Stage 2A – North Penrith Mixed Use Development (SSD 5243)

Council officers have reviewed the Environmental Impact Statement (EIS) and accompanying plans and reports submitted with the application. Comments and recommended conditions of consent in relation to key assessment issues are detailed in the attached table.

Stage 2A – North Penrith Mixed Use Development (SSD 5243)

Figure 4-1 Location of interpretive devices in the Stage 2A Works includes the art walls indicated by the number 3 and the pavement alongside Speedway Circuit, indicated by the number 12.
Source: Place Design Group Thornton Park Landscape Concept, p.5.

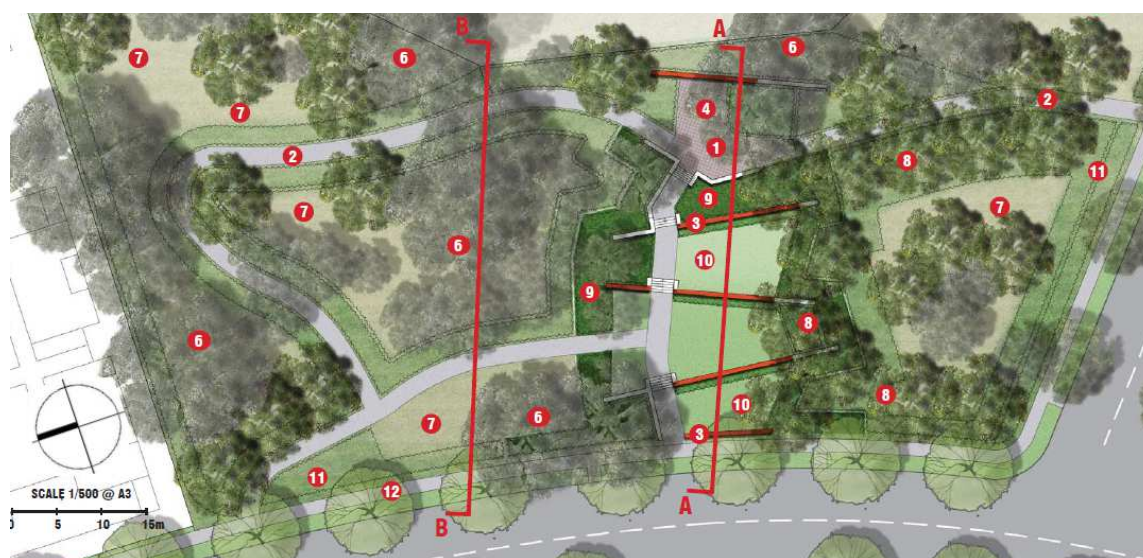
Heritage	<u>Comments</u> • Council's Heritage Adviser concurs with the Tanner Architects proposal for interpretation of the site as per Figure 4-1 contained on page 6 of the Heritage Interpretation Strategy dated June 2012.
